S. R. Marmon Neighborhood Association
P. O. Box 7434
Albuquerque, New Mexico 87194

Robert Lucero, Development Hearing Officer
Plaza del Sol Building
600 Second NW
Albuquerque, New Mexico 87102

Re: PR-2023-008674 (Playa del Sur/Miami)

Plat for
 Playa Del Sur
 Being Comprised of
 Portions of Tracts 308, 309 and
 310, Unit 8, Town of Atrisco Grant
 City of Albuquerque
 Bernalillo County, New Mexico
 January 2024

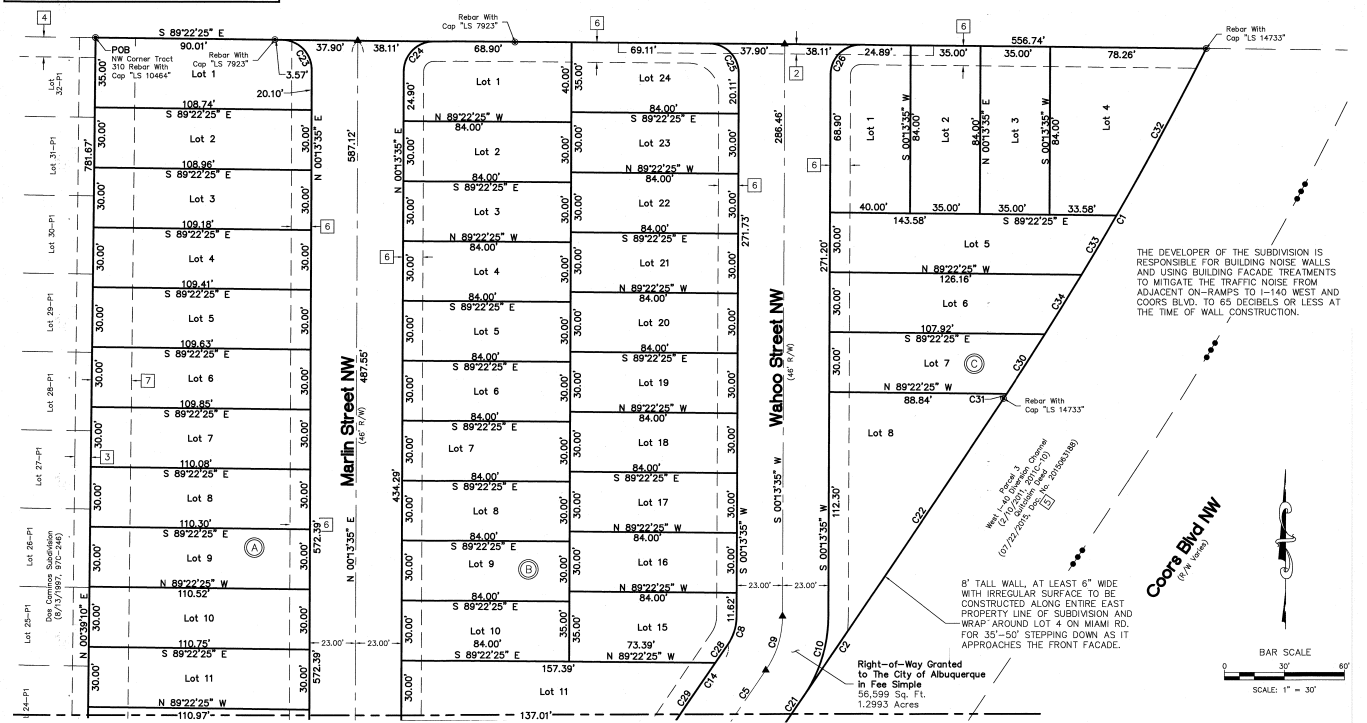
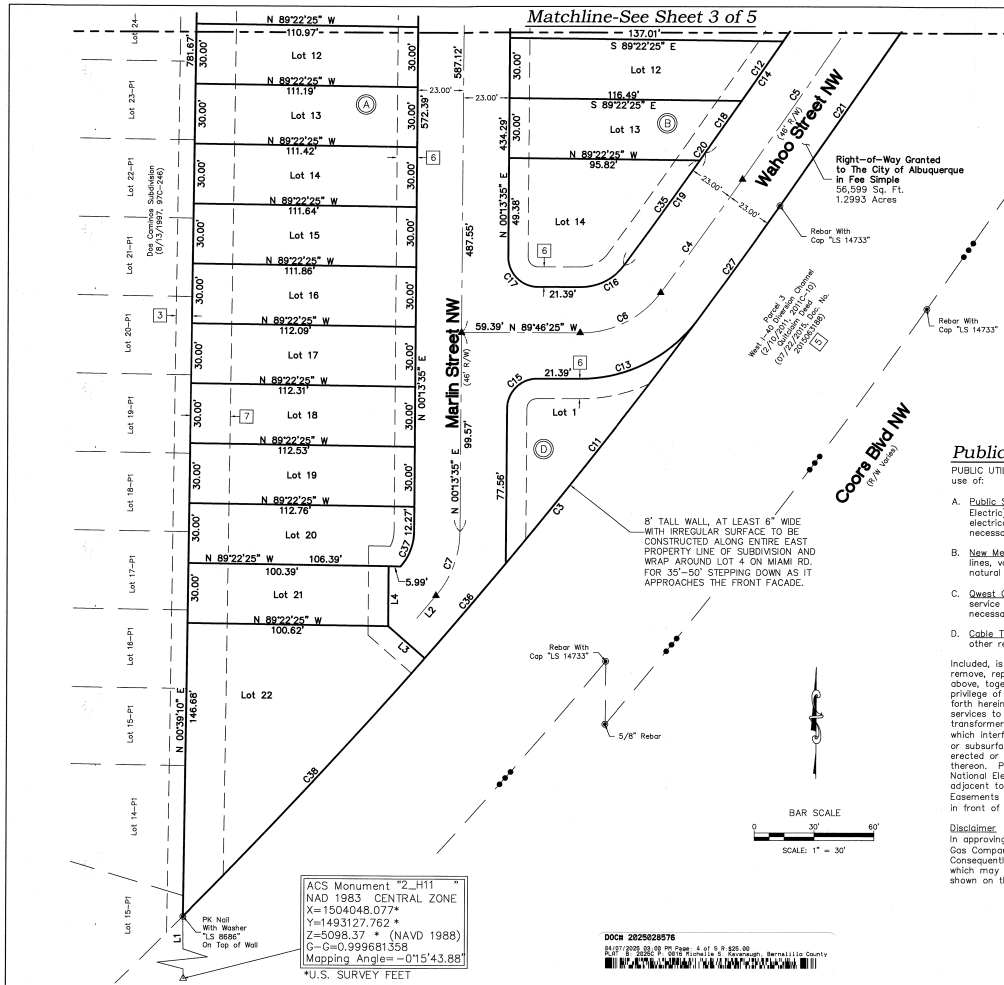
2. We seek confirmation of a 45' set-back from west side of townhouses to the rear wall of properties on Camino Contento. **Loss of view and privacy are sufficient for parties on the east side of Camino Contento to have standing as aggrieved persons under New Mexico case law (*Village of Mesilla v. City of Las Cruces* 120 N.M. 69 (1995), *Ramírez v. City of Santa Fe*, 115 N.M. 417 (¿1993?).** We want it clarified and confirmed that the physical distance from the rear wall of established residences on Camino Contento to the western-most wall on the new townhouses on Marlin will be at least 45' and will not be decreased and will be increased if possible. When considering staff comments regarding noise mitigation, we support an option of eliminating the units shown on the plat as facing Miami Road and increasing the distance between the western property boundary and townhouses on Marlin. We are dubious of remedies requiring a waiver or variance. Ms. Plant, of AMREP SW, assured me during a phone conversation in September or October of 2023 that no variance or waiver would be sought. **Reducing the number of units in the subdivision could preserve this assurance and address noise mitigation, excessive block length, and view and privacy preservation for residents on Camino Contento.**

3. **A missing action item from the facilitated meeting report is green space within the subdivision--either a pocket park or landscaping.** Mr. Liker agreed to look at this during the

facilitated meeting in addition to the presented exterior colour scheme (**use of earth-tone colours rather than stark white and black**). We would like open space or green space to appear on the plat. *City of Rio Rancho v. Amrep Southwest Inc.*, 150 N.M. 428 (2011) alleged that AMREP SW did not properly preserve open space as agreed.

LOT AREA: 2500 SF
 LOT TOTAL: 45 LOTS

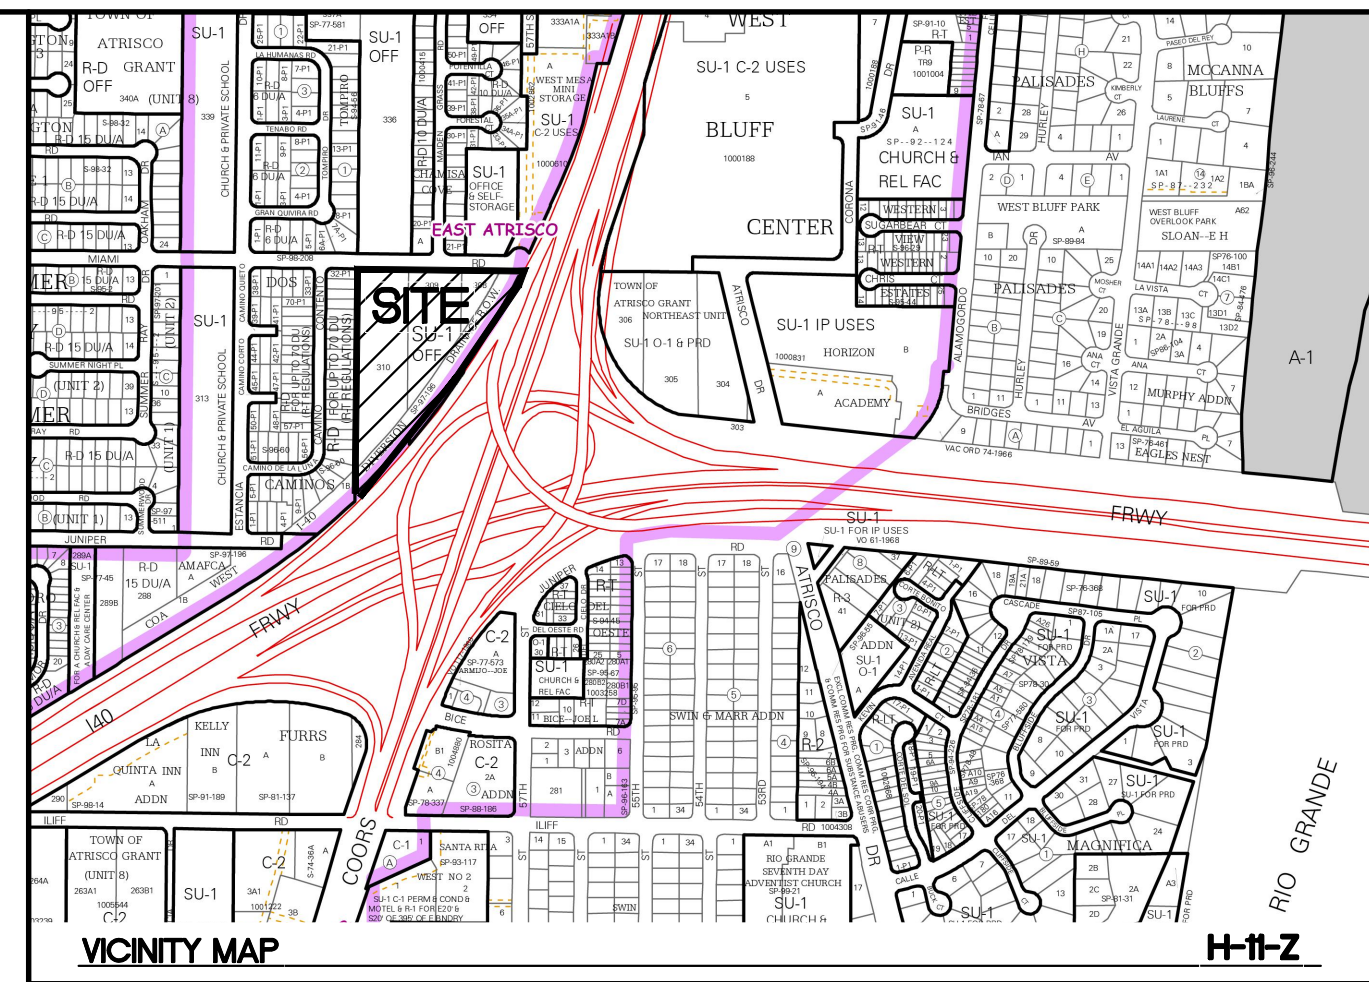
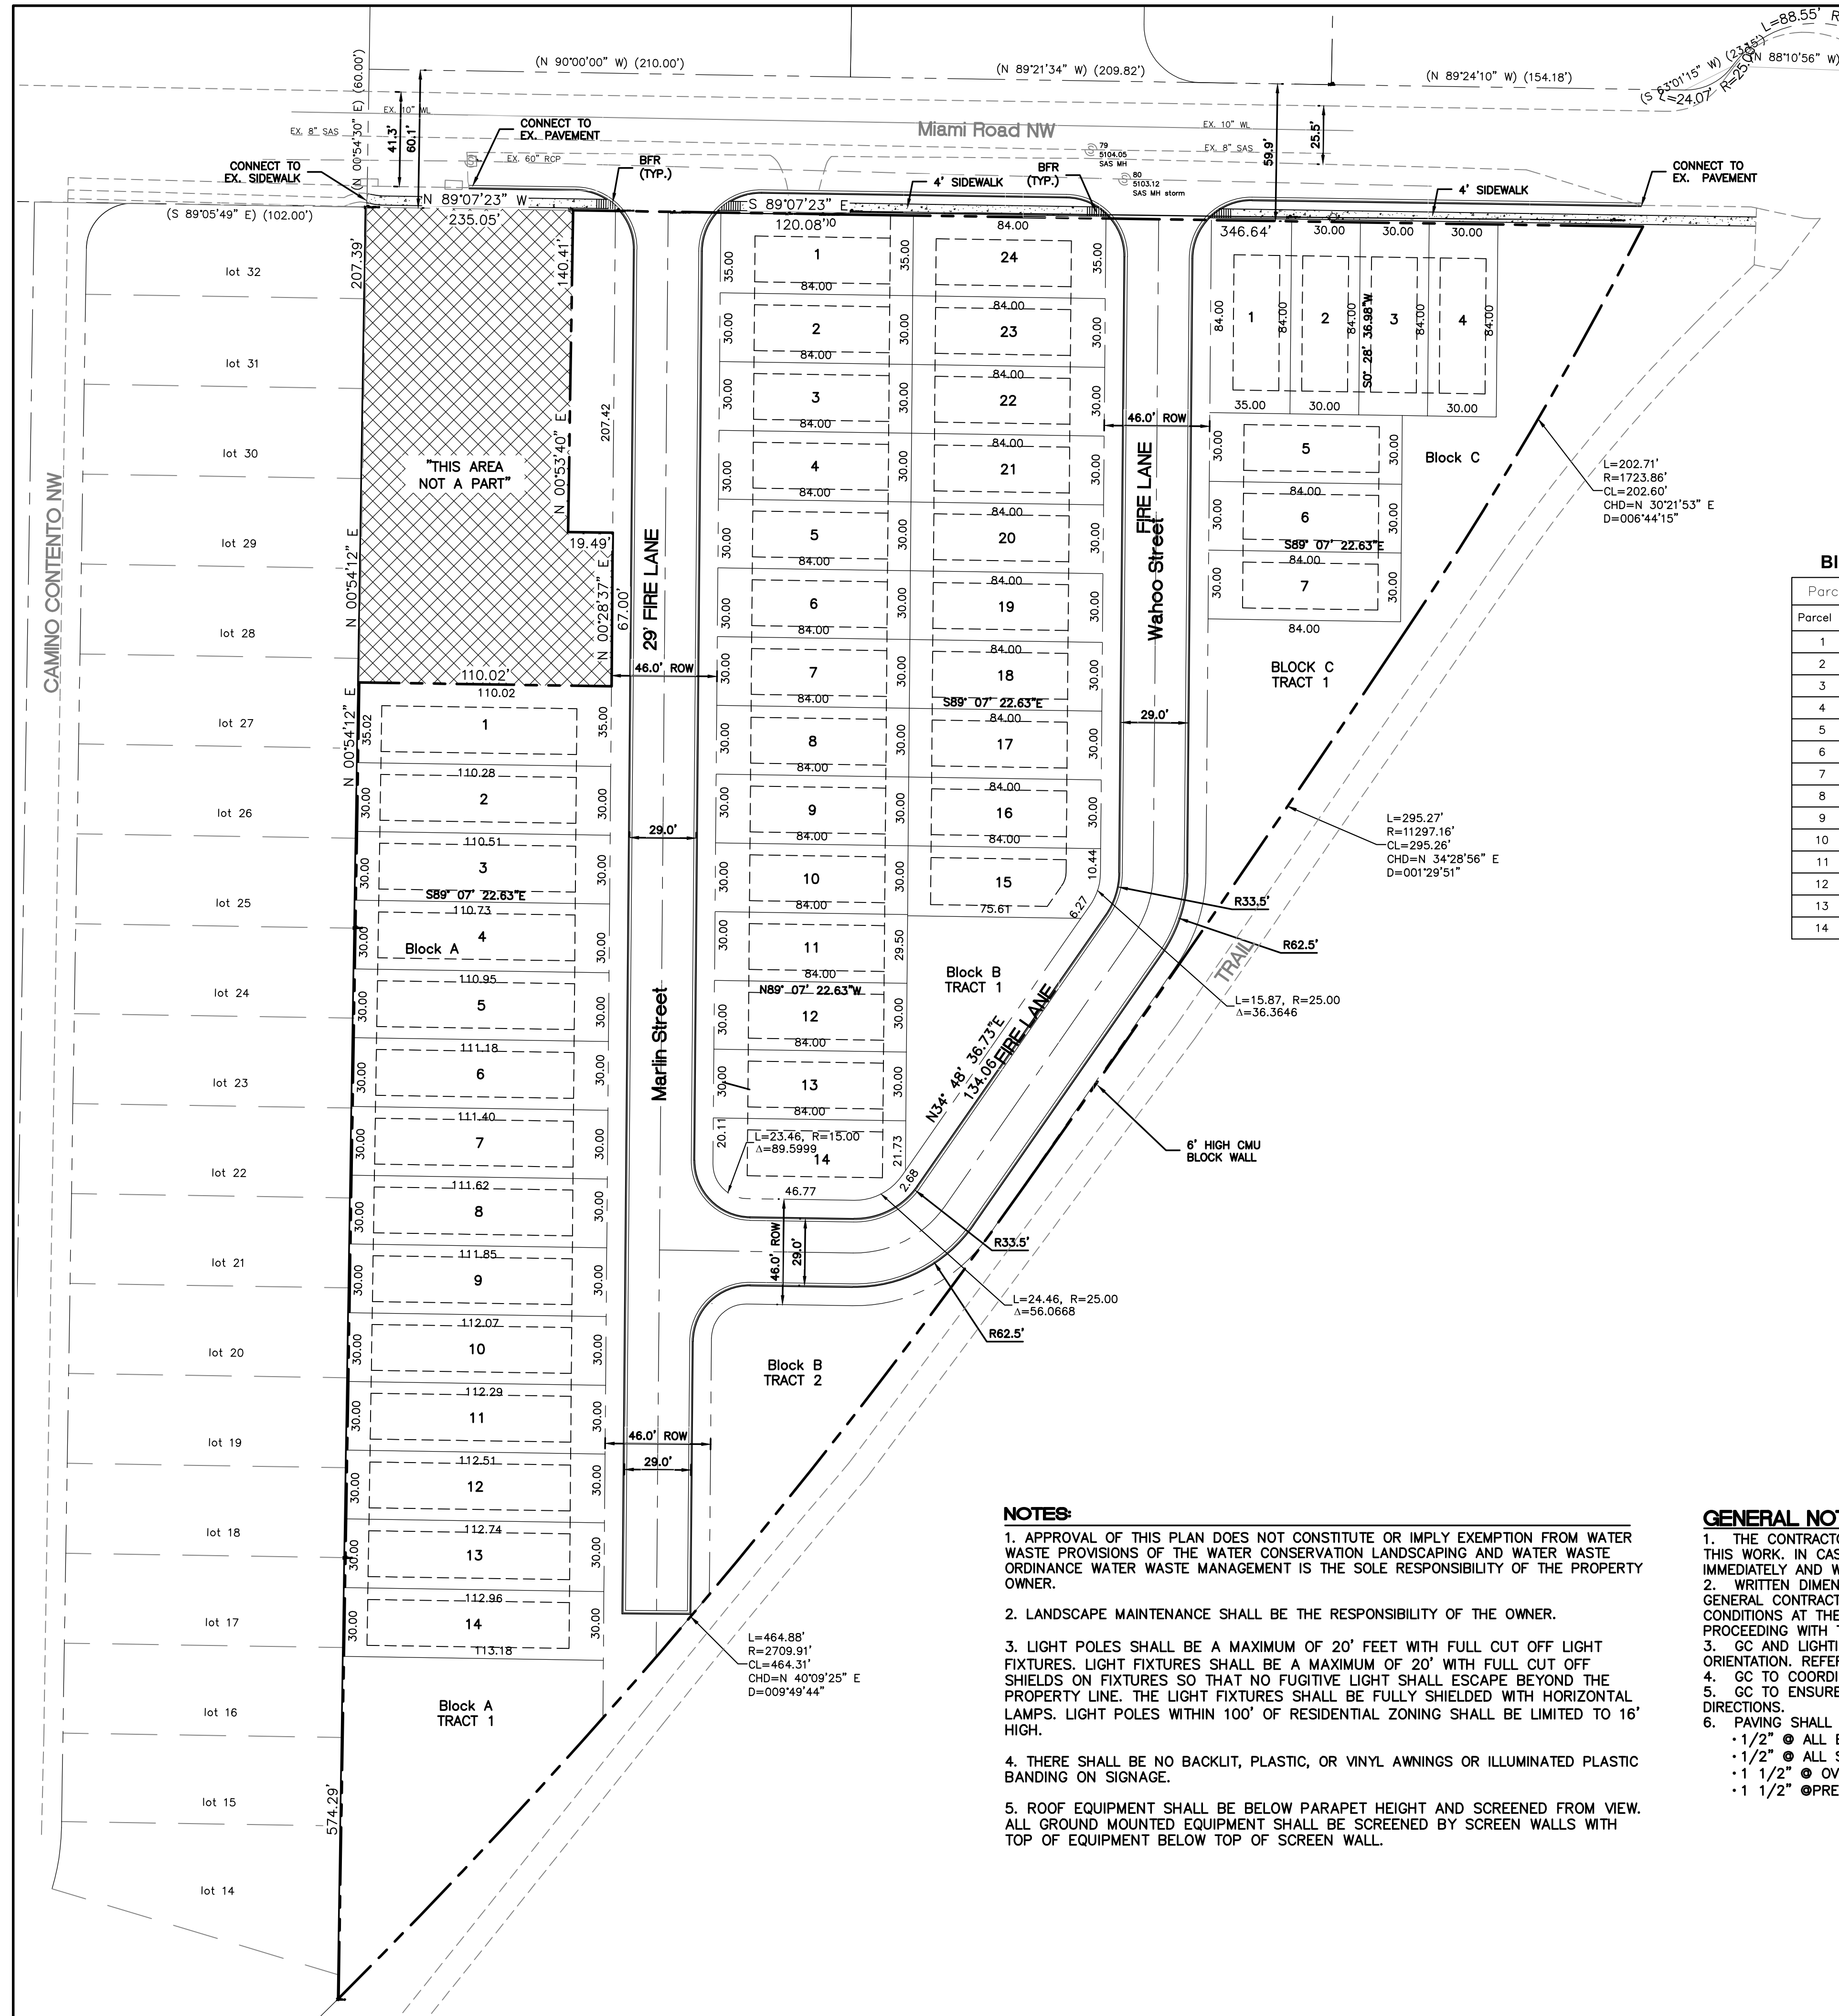
1. AMREP and Tierra West presented information to the neighbourhood in September and October 2023 that indicated a 45-unit subdivision of two-story townhouses. The site map submitted to the DHO is for 55 units. This represents a sizeable increase in expected traffic into and out of Playa del Sur, further negatively affecting residents on Maiden Grass Road. **An action item from the facilitated meeting on April 30 is for Sergio Lozoya to research and share the threshold number of “trips” that automatically trigger a TIS requirement for residential areas. It does not appear that this was provided to all attendees of the facilitated meeting.**
